Historic England

Our ref: P00990015

15 October 2020

**VICTORIA TOWER, LUMB LANE, CASTLE HILL, ALMONDBURY,
HUDDERSFIELD, HD4 6TA
Application No. 2018/93591**

Job Title Castle Hill, Huddersfield	
Client The Thandi Partnership	
Status Planning	Company AD
Drawing Proposed Elevations Sheet 2 of 1:200 2	
Date October 2019	Drawn / Checked FWG
Drawing No. 3267 (0-) 09	Revision -

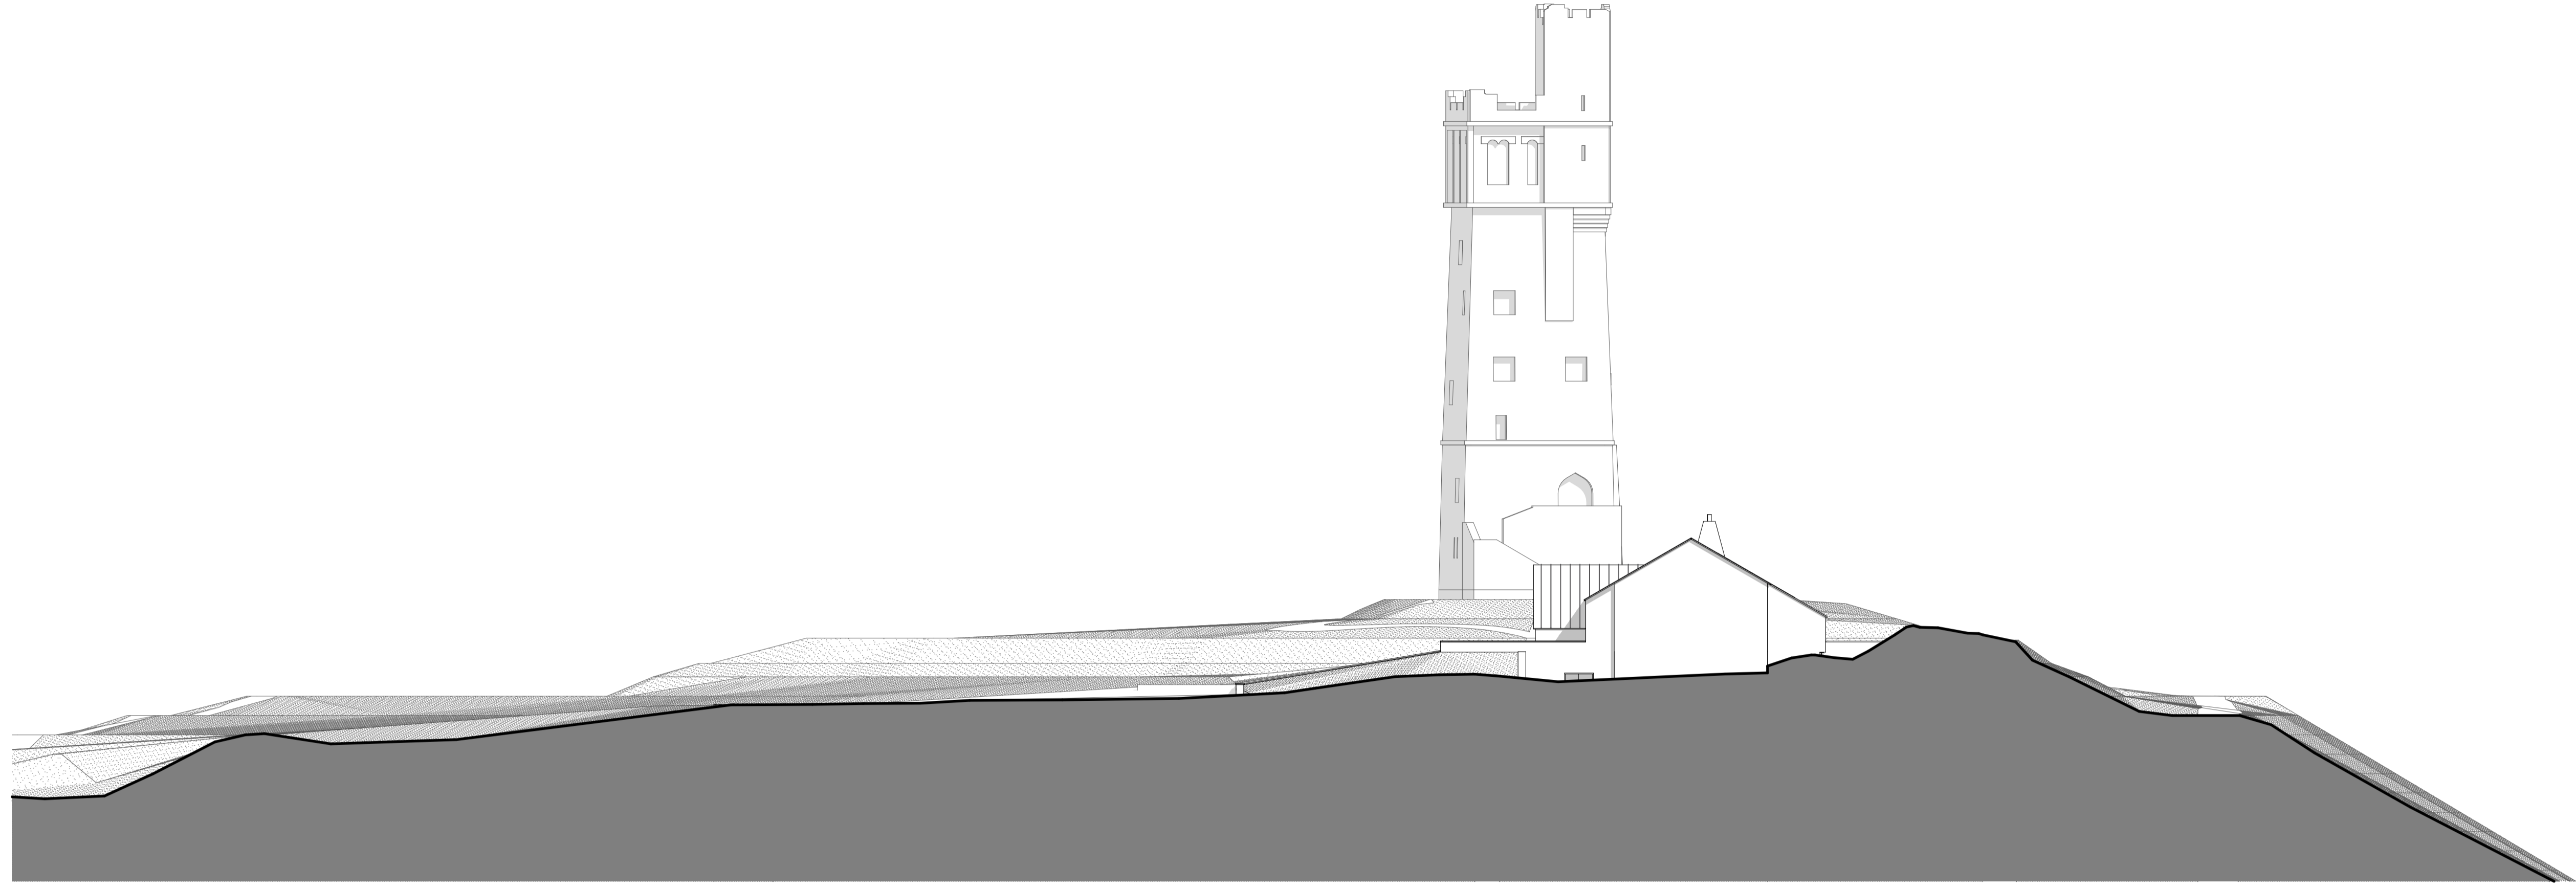
The choice of materials will be an important determinant of the quality of the design. We believe that in such a sensitive location the materials palette should be resolved and referenced on the application drawings.

- The Heritage Statement is updated in accordance with the current proposal
- The building materials are clearly identified and described on the drawings, and
- A detailed 'Heads of Terms' document is prepared to clearly define the benefits of the project and the methods of delivery.
